# CITY OF ALBUQUERQUE

RE: **Home Floor and Décor**  
**4936 Pan American Fwy NE**  
**Request for Certificate of Occupancy – 30 day Temporary**  
**Hydrology Final Inspection - Approved**  
**Engineer's Stamp Date 2/20/18 (F17D032)**  
**Certification Dated: 7/2/18**

PROJECT TITLE	4936 PAN AMERICAN FRWY NE MCLEOD AND I25 ALBUQUERQUE, NEW MEXICO 87120	DRAWN BY:	OLIVIA WOOTEN
PROJECT MANAGER	JEFF WOOTEN	JOB NO.	2017018
SHEET TITLE	Grading Plan	SHEET NO.	C1.1
DATE	4/4/2018	SHEET	2
SCALE	AS NOTED

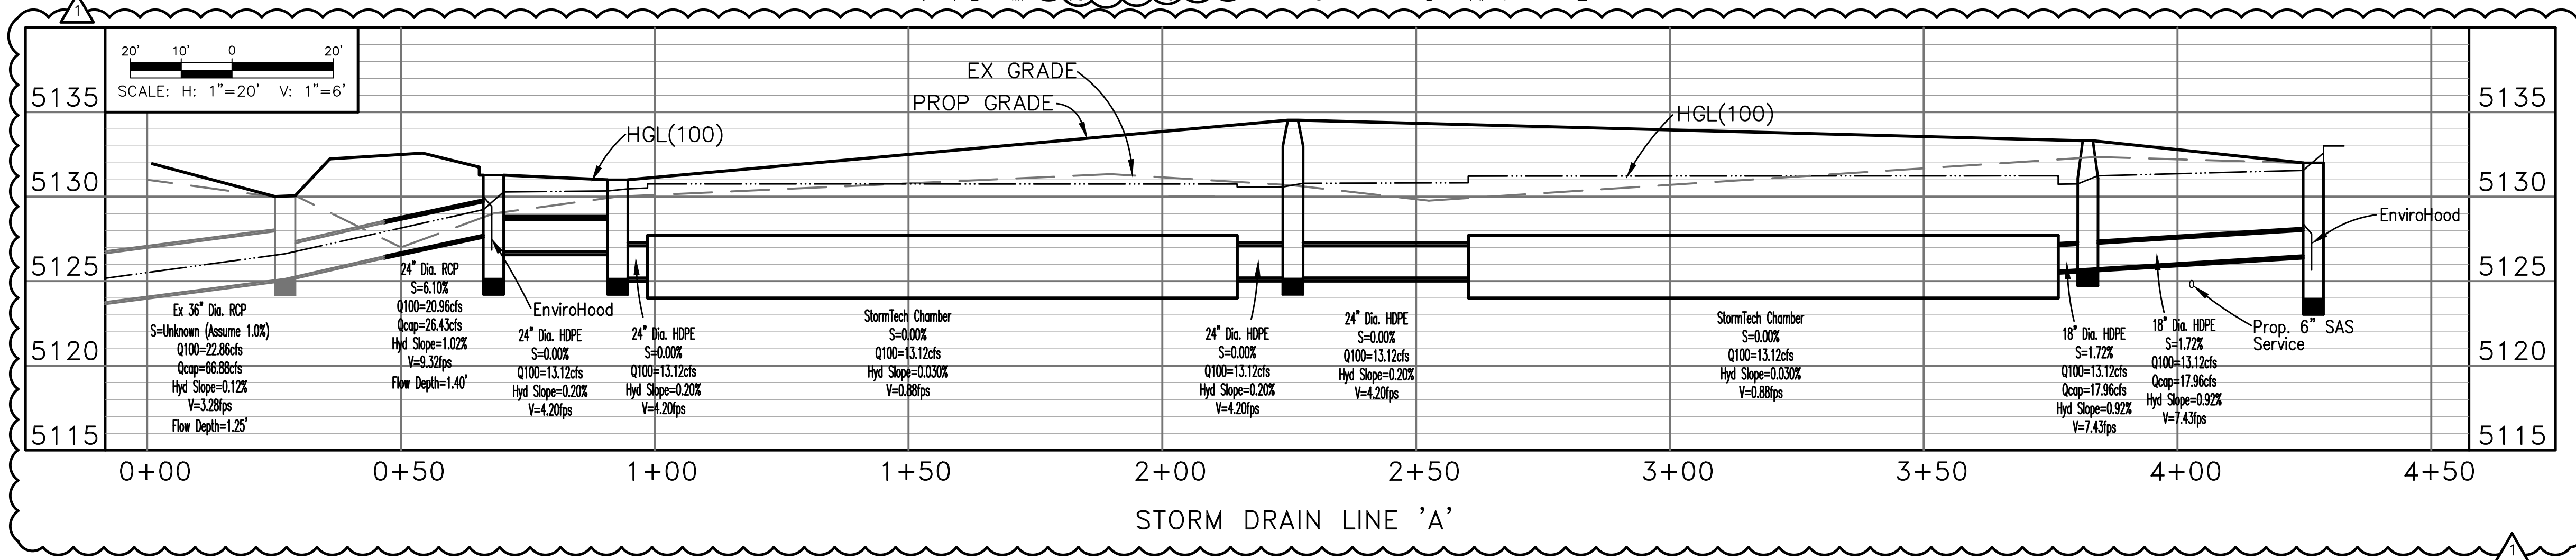
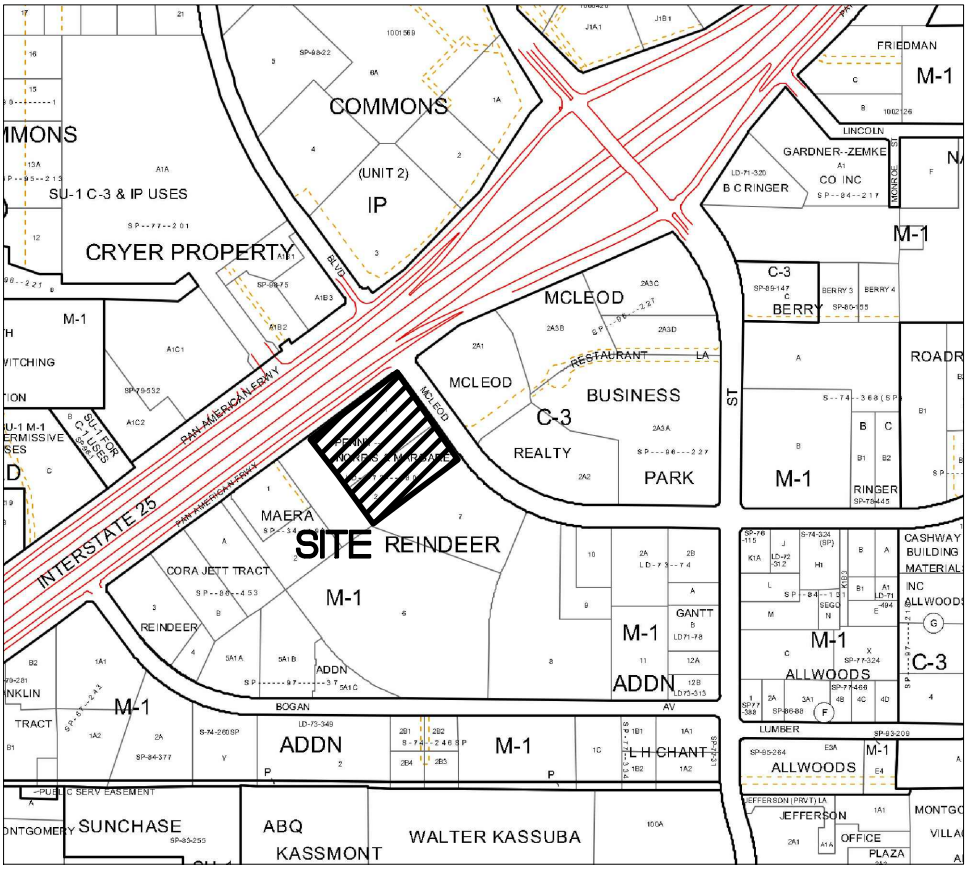
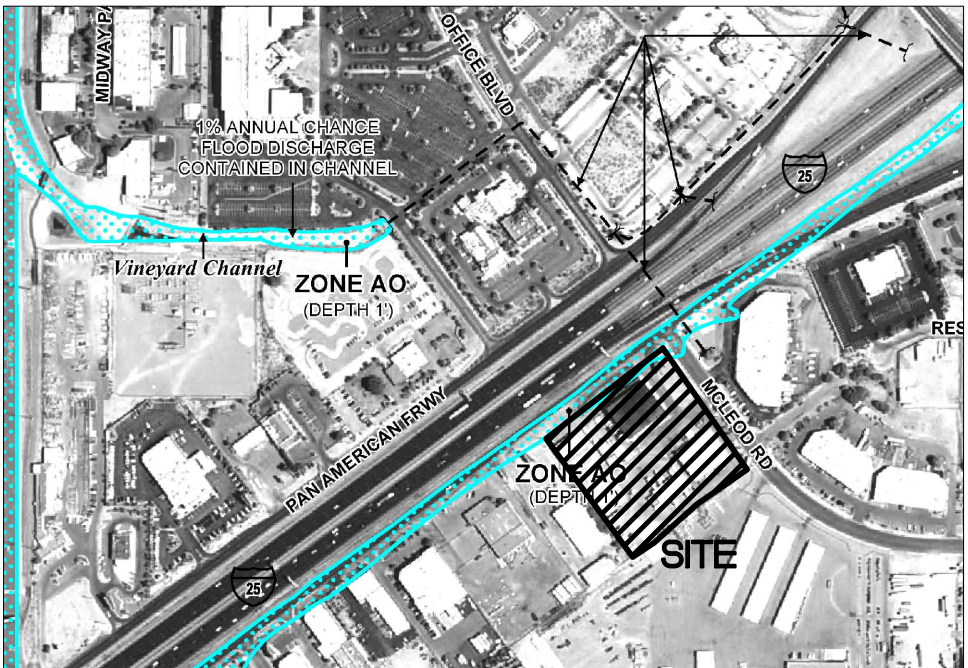
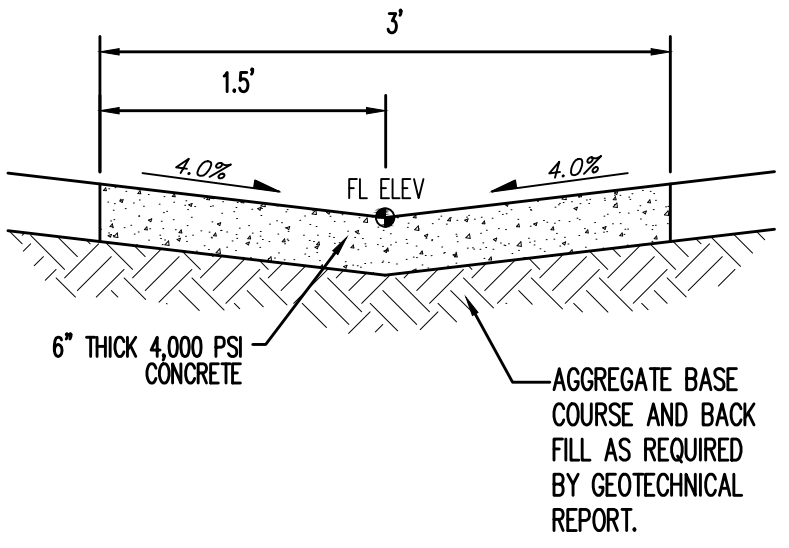
1. The most-recent approved grading and drainage plan needs to be certified. This is: Sheet C1.1 w/ Stamp Date: 4/4/18, and Sheet C1.2 w/ Stamp Date: 3/28/18.
